Final Report - Corrections Required **Application No. SUBD-26-0036**

Description : 39 single family lot community directly north of filing 10.

Address : 0 Warrick ST

Document Filename : FP_V1_5-6-26.pdf

REVEL AT WOLF RANCH
FILING NO. 11
JOB NO. 2555.48
MARCH 8, 2026
SHEET 1 OF 2

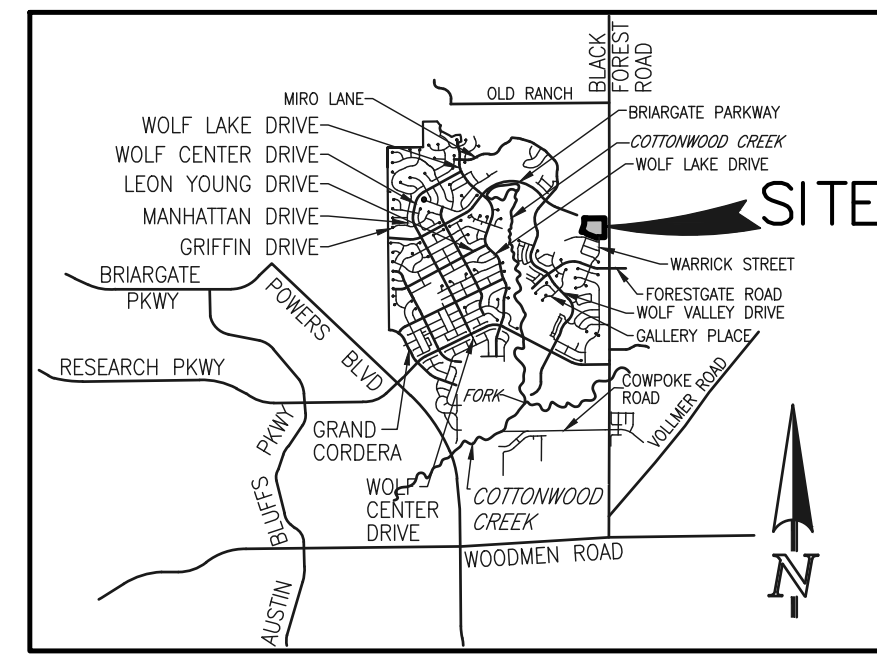
The Old Ranch Metropolitan District is shown as a property owner, but there is no signature/notary certificate provided.

please check/revise the date

Not seeing that Forestgate is anywhere in the vicinity. Does it apply to this plat?

REVEL AT WOLF RANCH
 FILING NO. 11
 JOB NO. 2555.48
 MARCH 8, 2026
 SHEET 2 OF 2

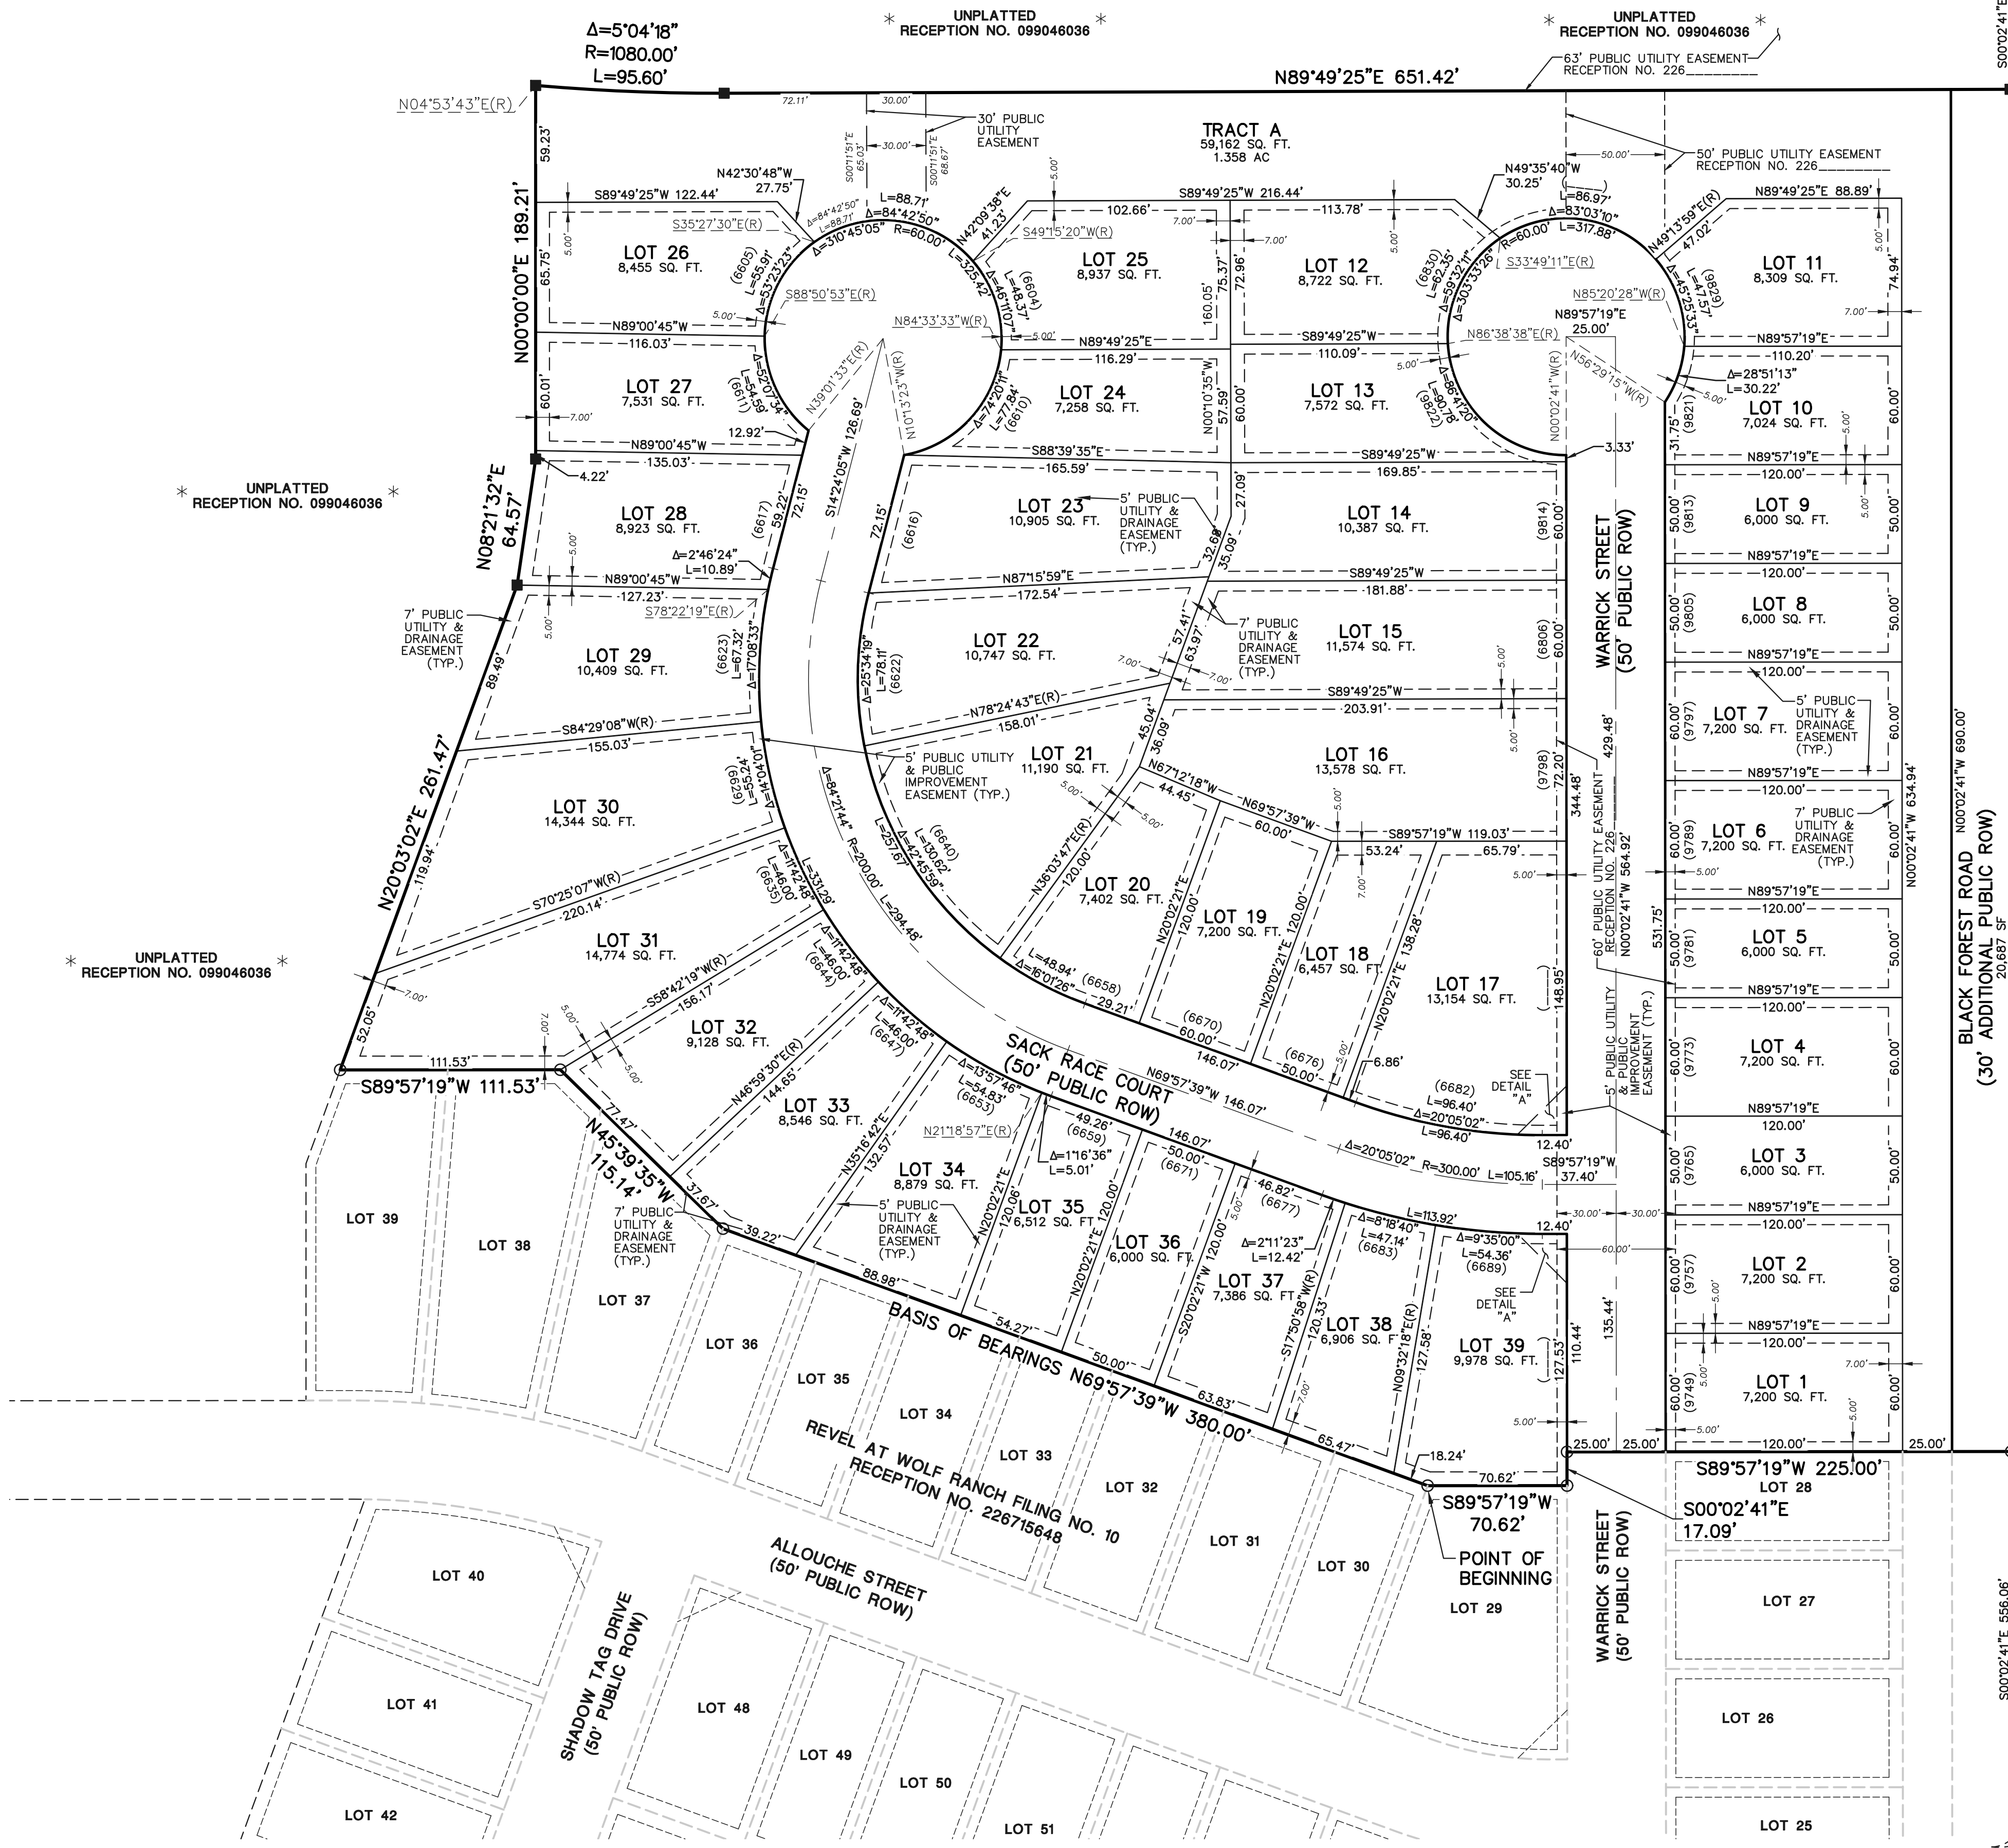
19	2	Caelen Wendt : Col Springs Utilities	Appears that this Utility Easement has been recorded via Rec. No. 226022691. Please change all instances this easement to 'Utility Easement'
1	1	Molly O'Brien : Planning	Add City file number to all sheets
9	1	Cory Sharp : Planning	planning review fee: 39 lots at \$107.49 per lot = \$4192.11
10	1	Cory Sharp : Planning	please revise to match drawing N 00-00-00 E
11	1	Cory Sharp : Planning	please check/revise the date
12	1	Cory Sharp : Planning	please check/revise USAFA noise notice not the latest note: "This property may be impacted by noise and/or similar sensory effects caused by, but not limited to, the normal daily activities from the United States Air Force Academy's Airmanship Program, combat training, and special events. These activities include, but are not limited to, fixed and rotary wing aircraft, live weapons fire training at the firing range, simulated explosives, controlled hunting during hunting seasons, and other activities that may produce noise, vibrations, dust, smoke and all other effects that may be produced by such activities and experienced beyond the Installation's boundaries. This notice shall remain in effect until the Air Force Academy shall cease to be used for flight, and military training purposes and special events, or until all airfields on the Air Force Academy shall cease to be actively used and special events are permanently discontinued. This notice shall run in perpetuity with the land."

17	1	Caroline Miller : Planning	As detailed with PUDD-24-0014 and D20 comments, Park and School Fee boxes will be notated as 'Land Dedication' by staff on plat mylar. Citywide Development Impact (Police & Fire) Fees will be due at time of building permit.
24	1	Molly O'Brien : Planning	Comments from El Paso County have been uploaded to record in a separate document. Please review comments.
13	2	Cory Sharp : Planning	the easement lines along the internal lots within the recorded adjacent plats can be removed
